WINGS NURSERY, LIDSEY, WEST SUSSEX

PROPOSED NEW ACCESS

Stage 1 Road Safety Audit

SR/LS/17/1545/RSA1

Drawing Title: Swept Path Analysis and Visibility Splays

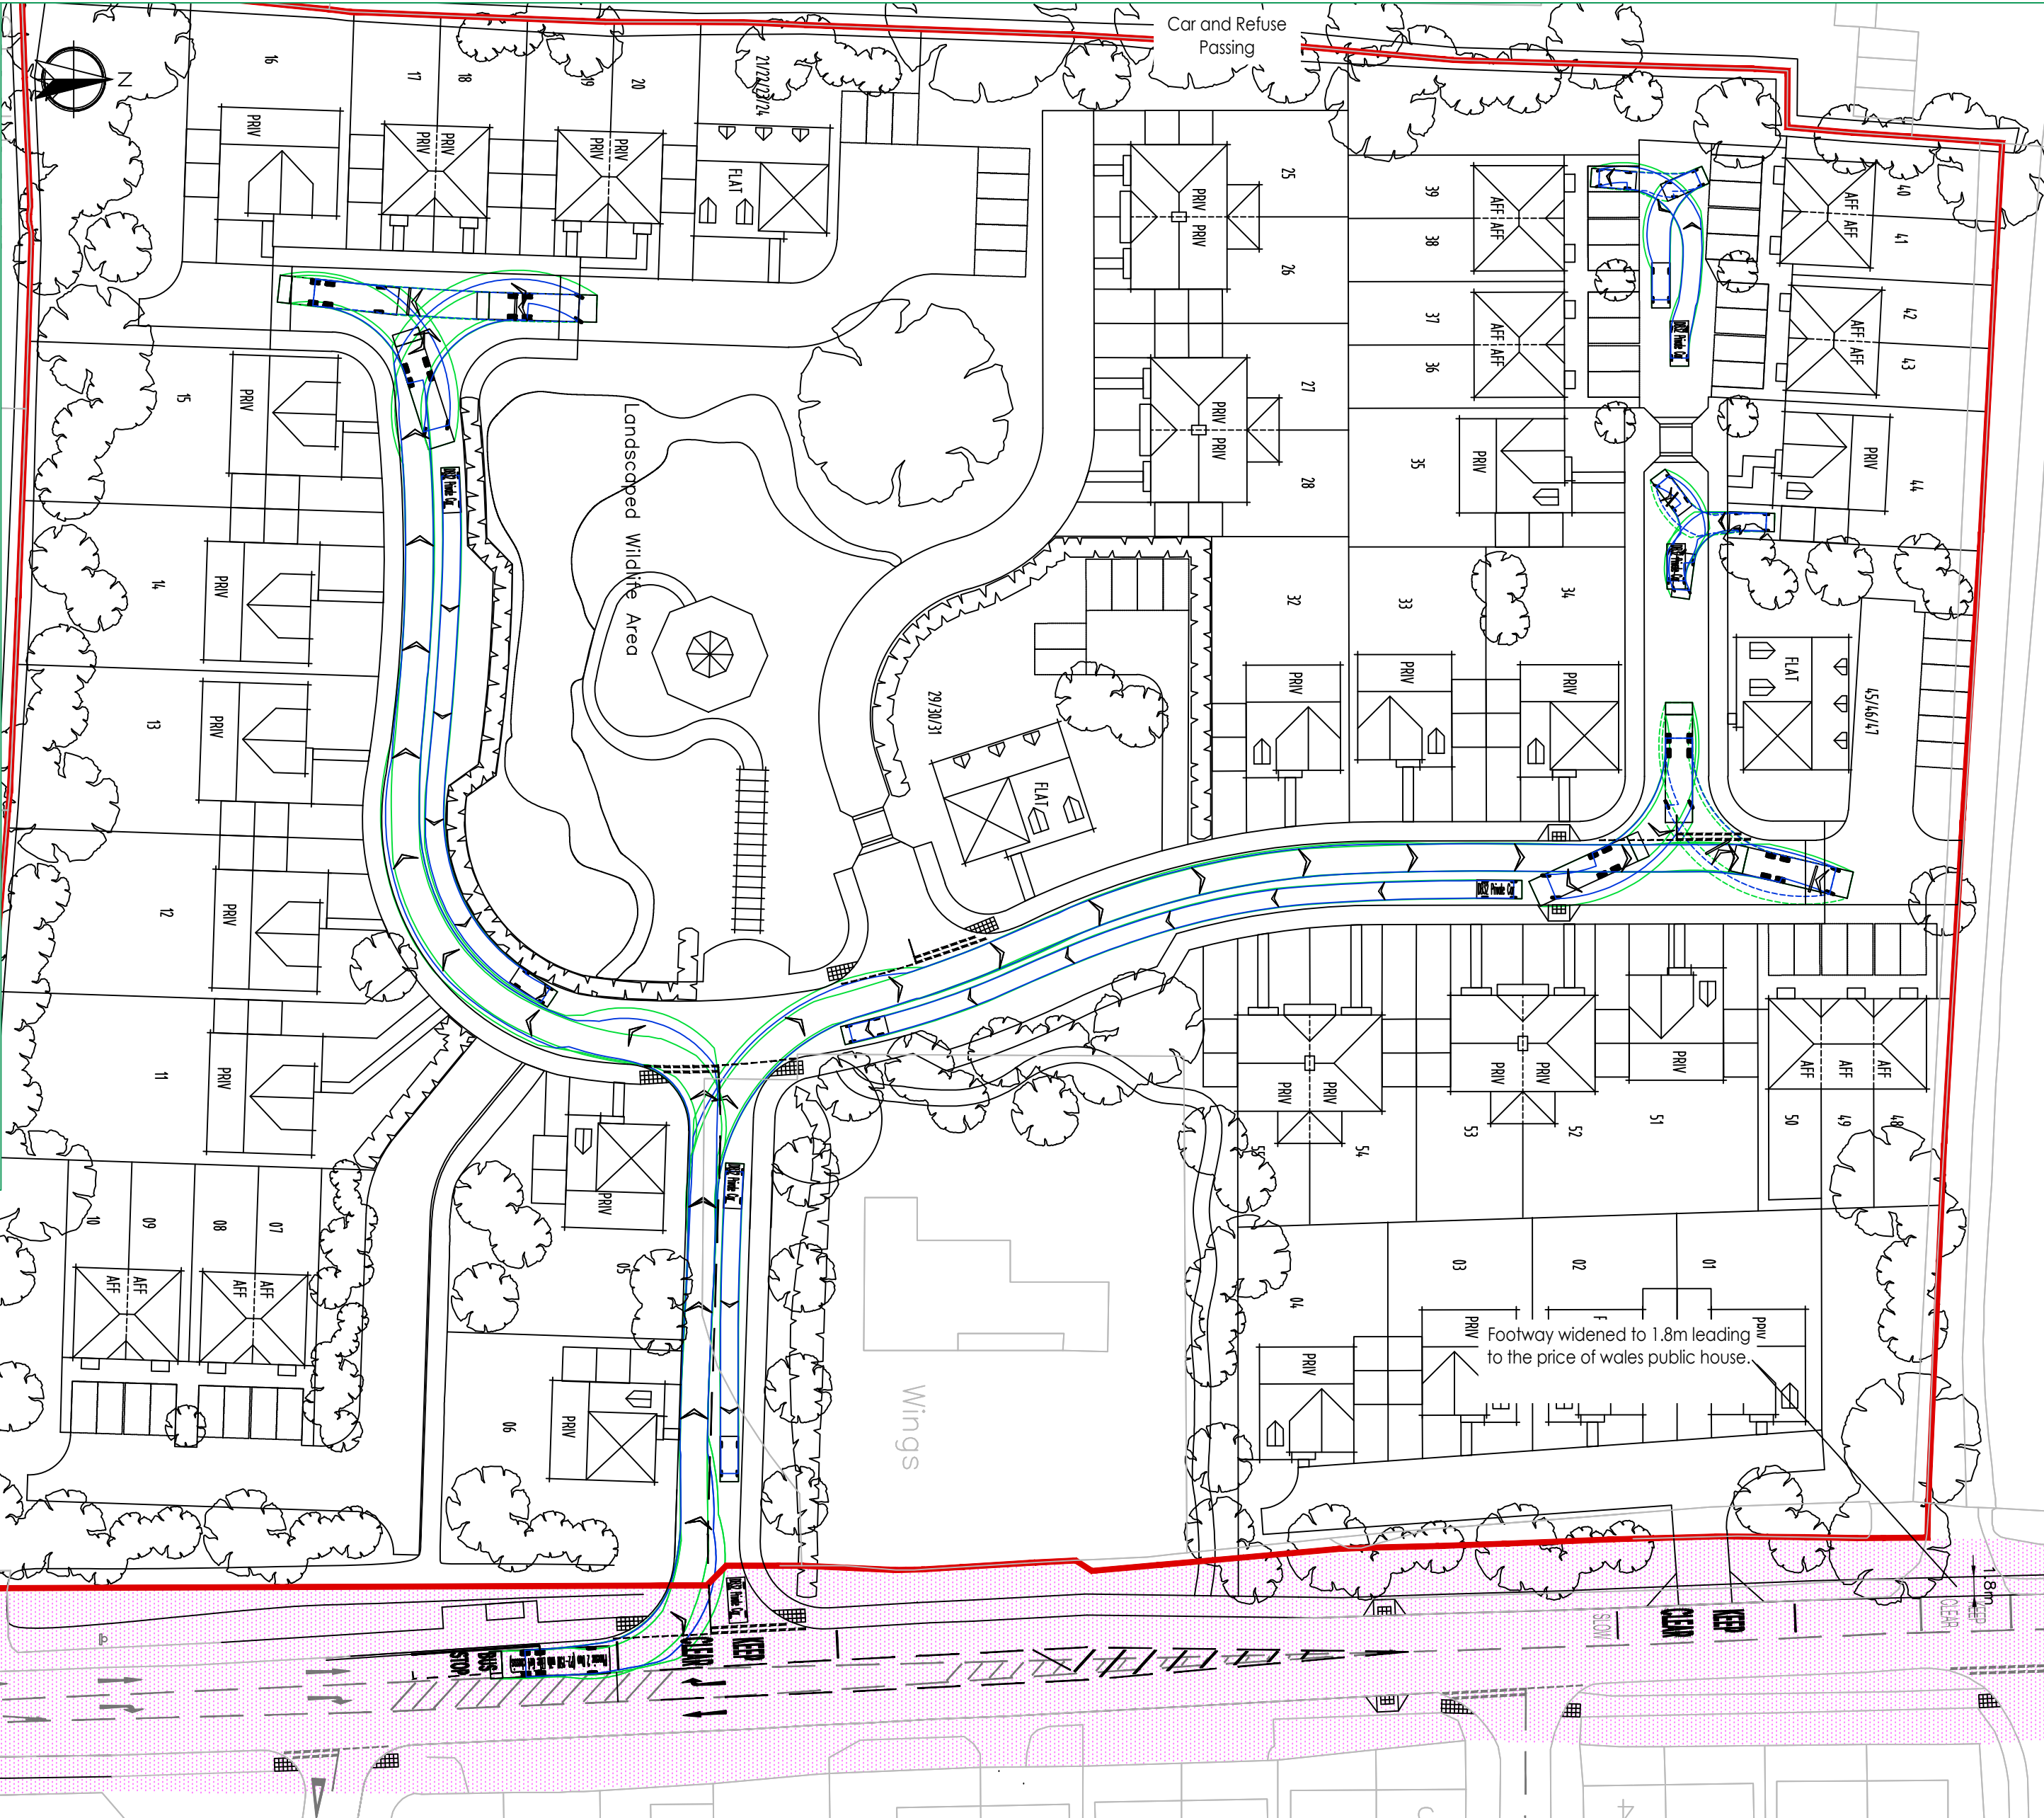
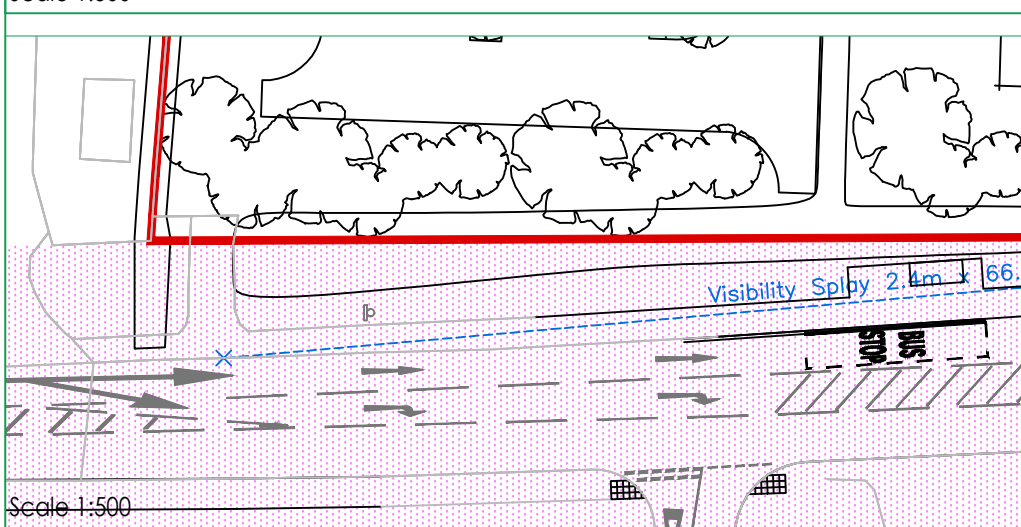
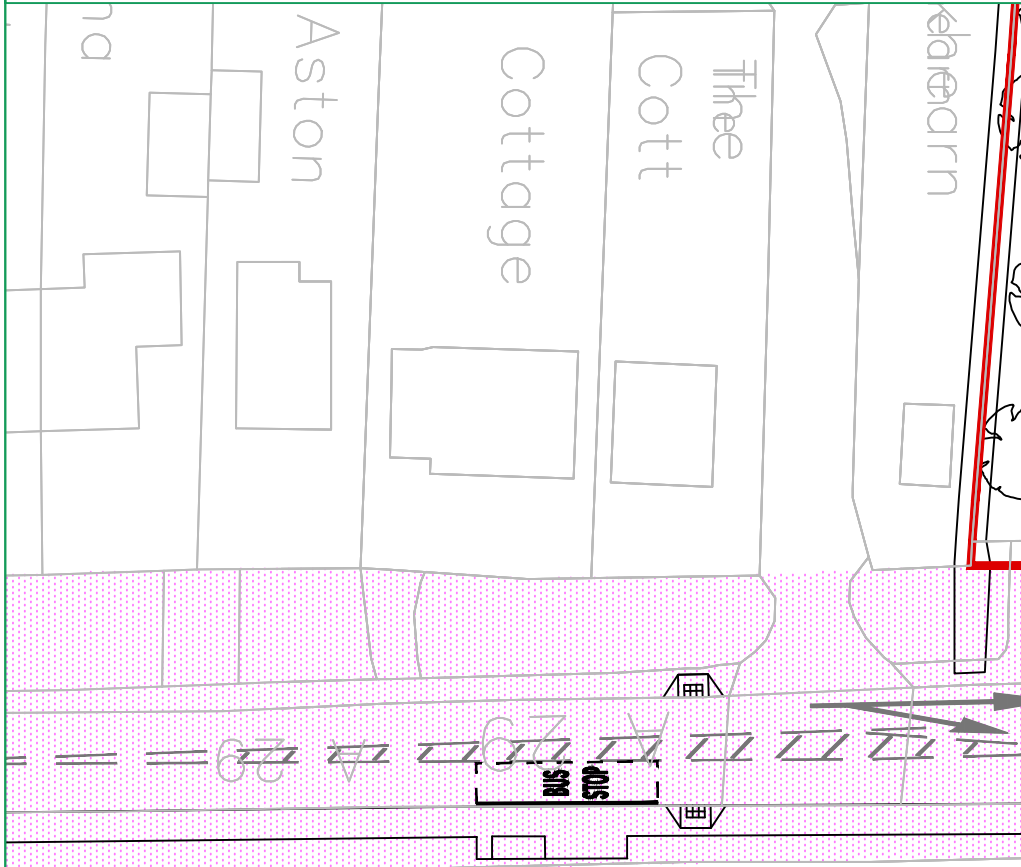
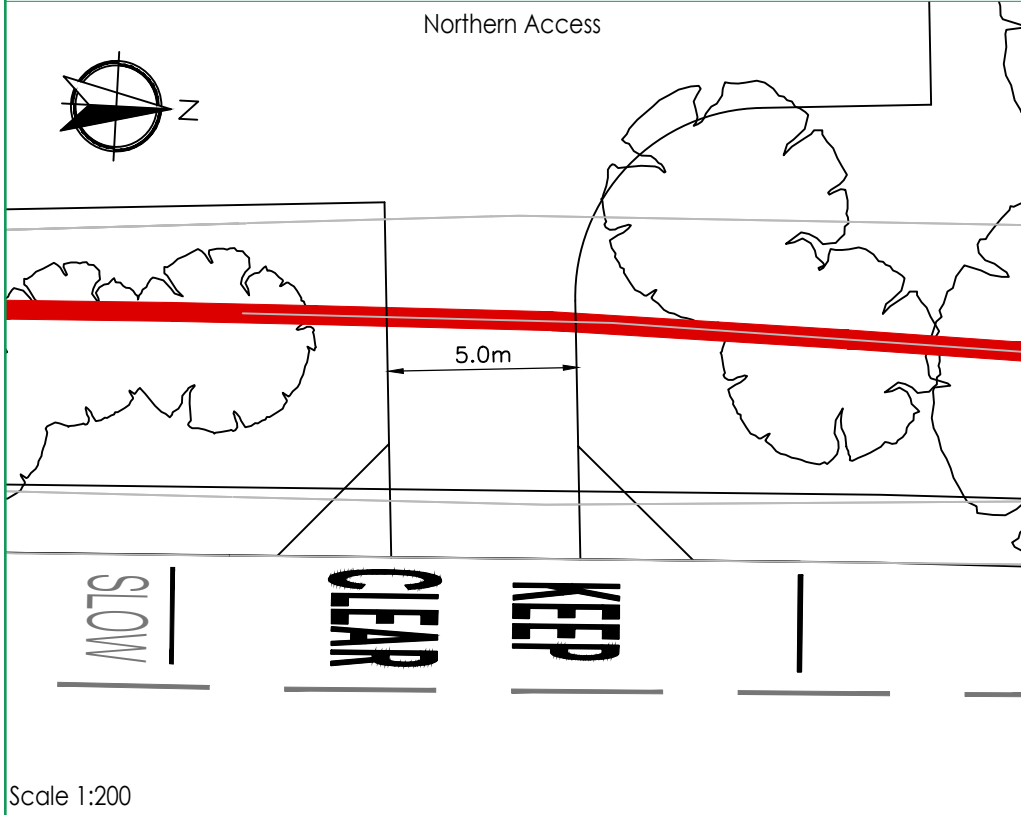
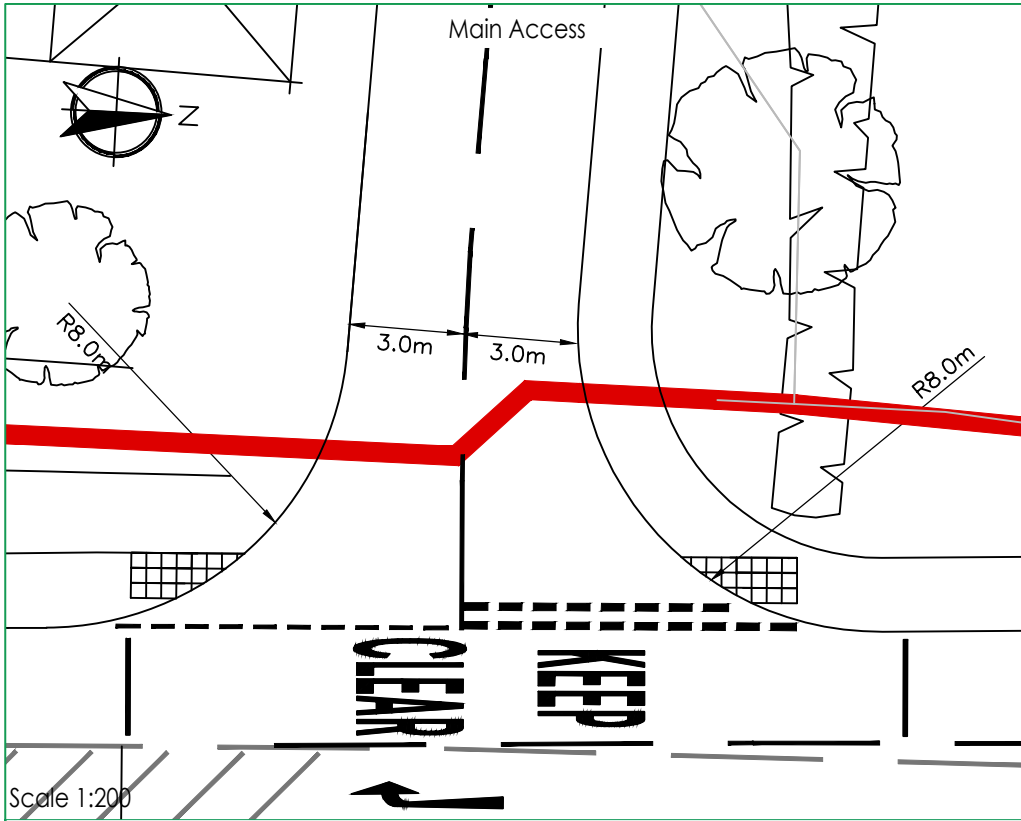
The Audit Team noted the tactile paving shown on the drawings do not conform to the tactile paving standards for an inline crossing point. There is a risk that this would confuse blind and partially sighted pedestrians.

The Audit Team noted that the trees to the north of the access were obscuring the visibility of vehicles exiting the development. There is a risk that sight lines would be hindered which may result in collisions.

Ensure that the correct tactile paving layout is installed.

Ensure that all vegetation is cut back and regularly maintained.
